# Planning Application Assessment – Delegated Report

**Planning Application Reference** : PL/2021/03311/PPFL

**Address** : Pear Tree Farm Meer End Road Meer End Solihull

**Proposal** : Replacement of an existing residential annex to Pear Tree farm.

Title:
Proposed Elevations

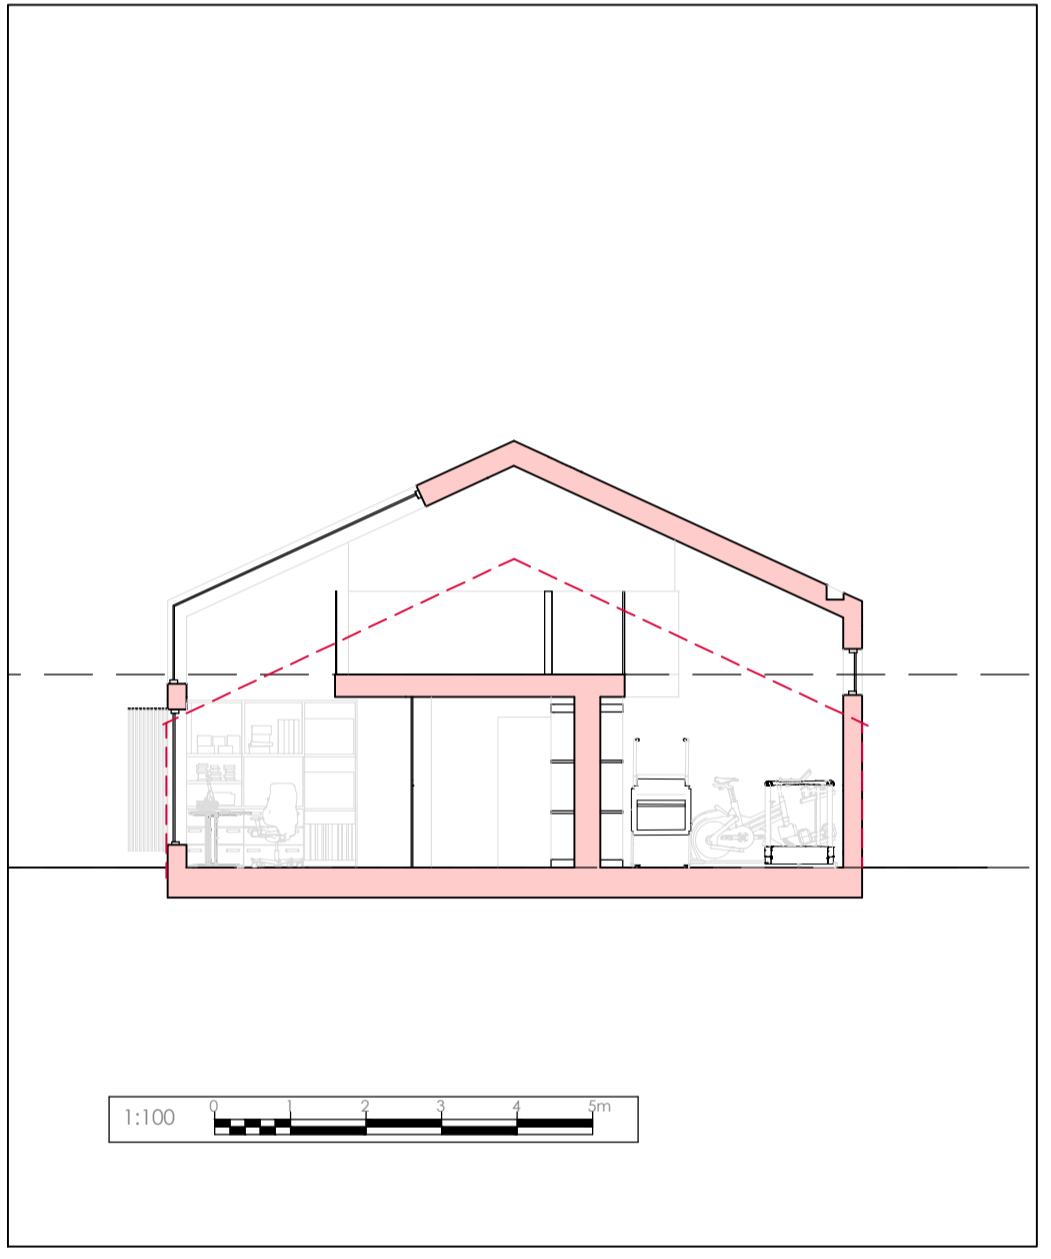
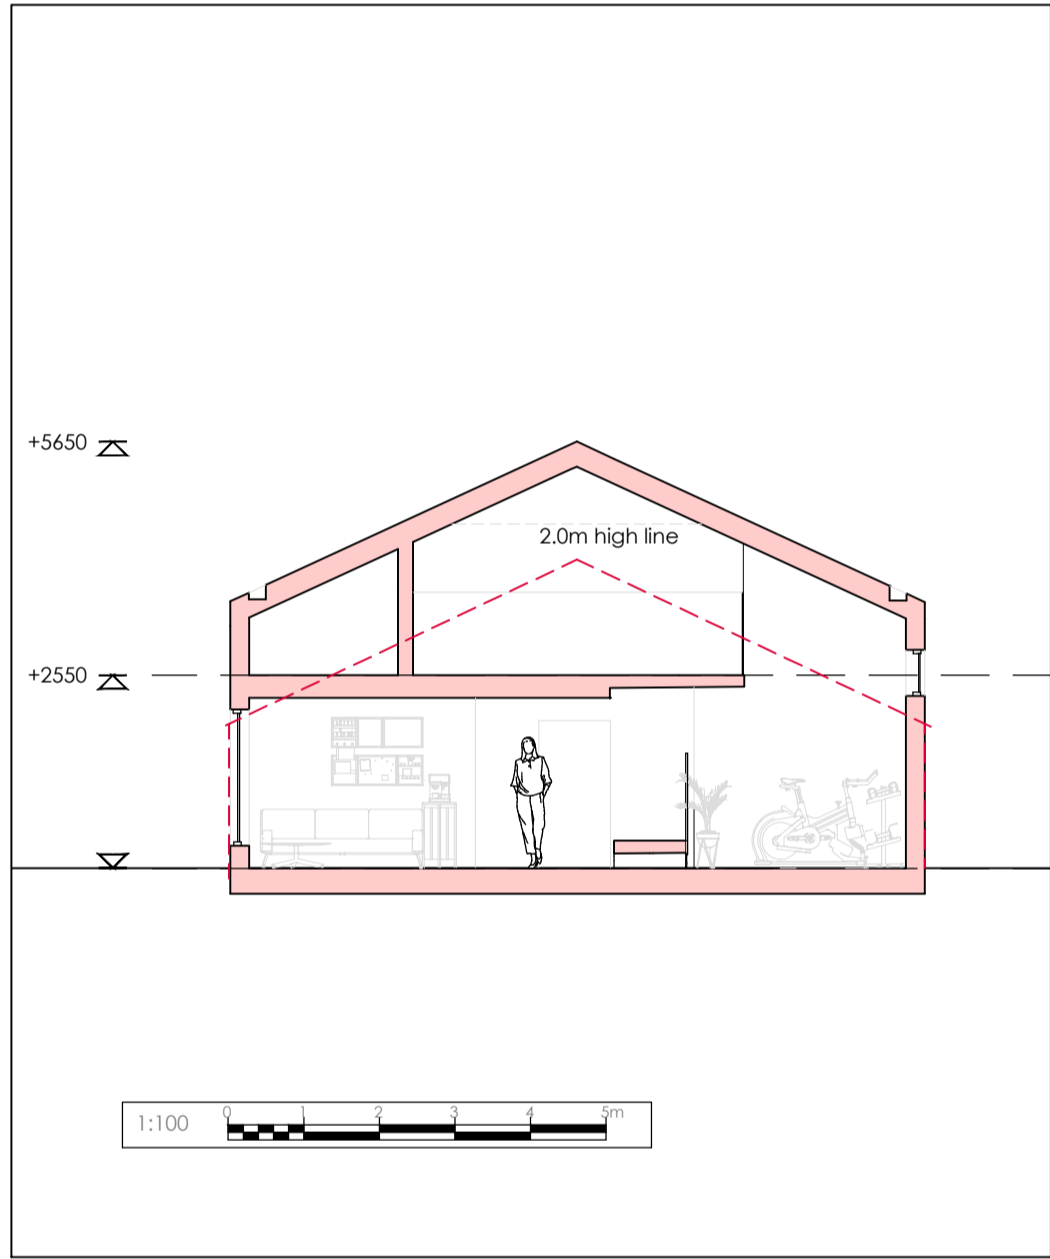
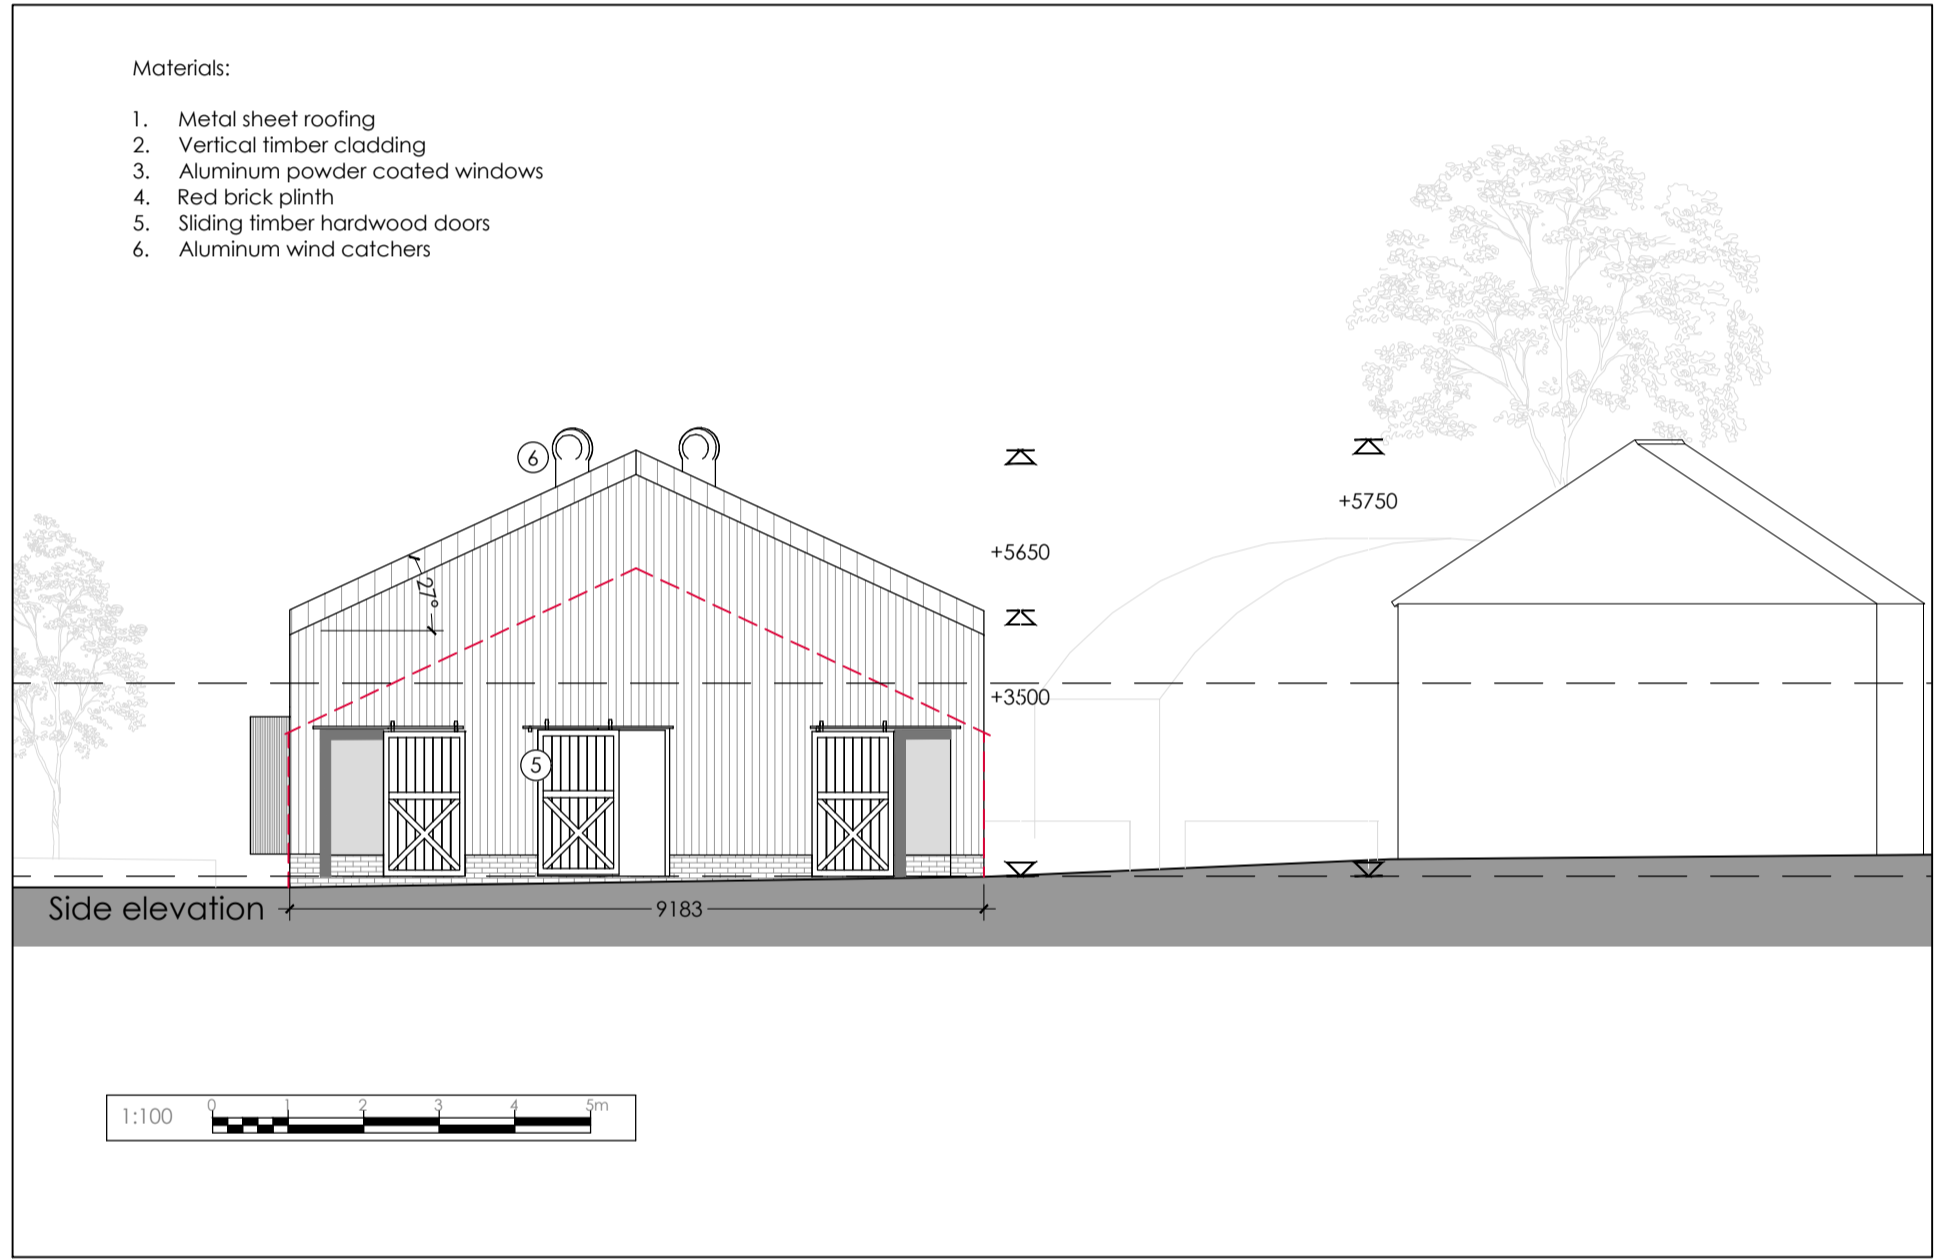
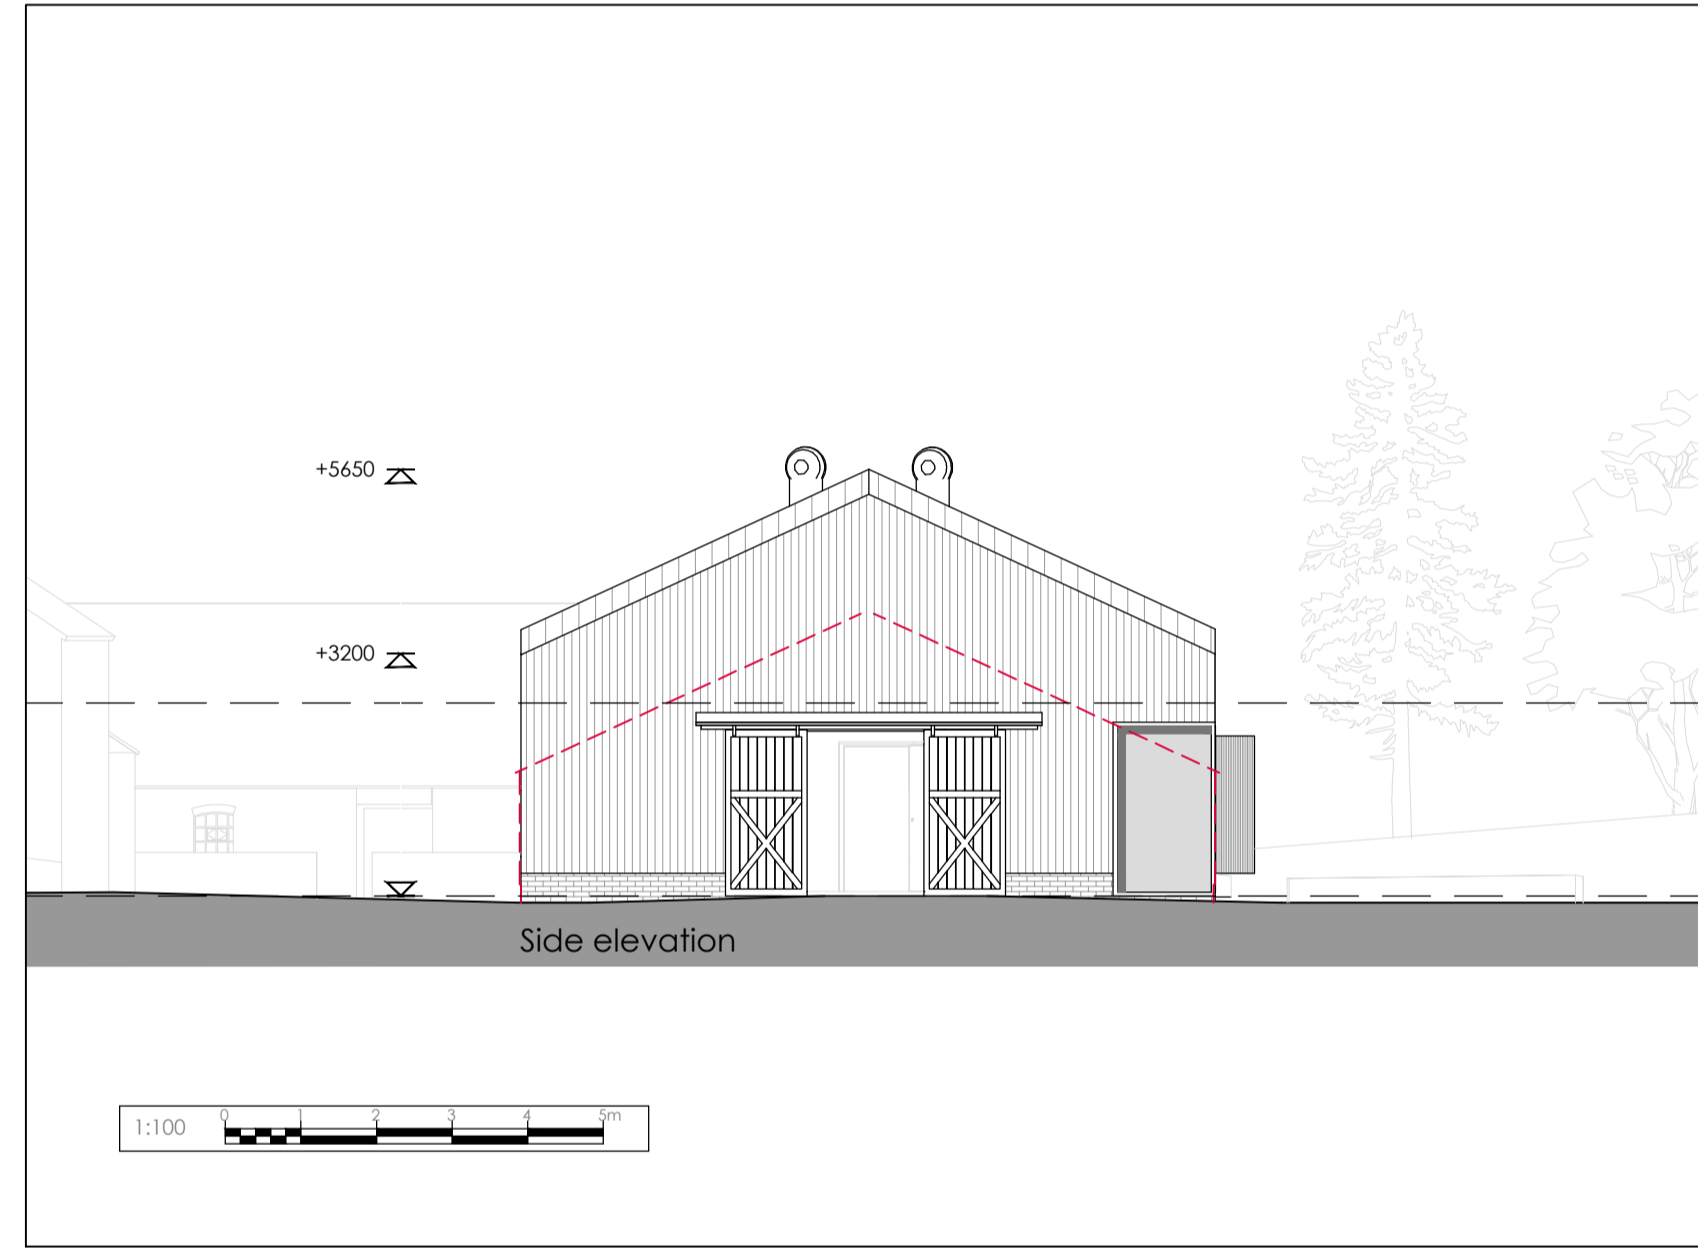
The proposed works involve the replacement of an existing ancillary dwelling which was a conversion of an agricultural building. The proposed expansion of the building upwards would be detrimental to the existing openness of this Green Belt. As the building would be significantly taller.

The existing building appears not to have been extended and the proposal will increase the eaves height from approximately 1.8m to 3.9m and the ridge height from approximately 3.9m to 5.5m tall. The volume of the existing building is approximately 481 cubic m and of the proposed replacement building will be approximately 777 cubic meters. The replacement building is clearly materially larger both in terms of its total volume and maximum height of ridge.
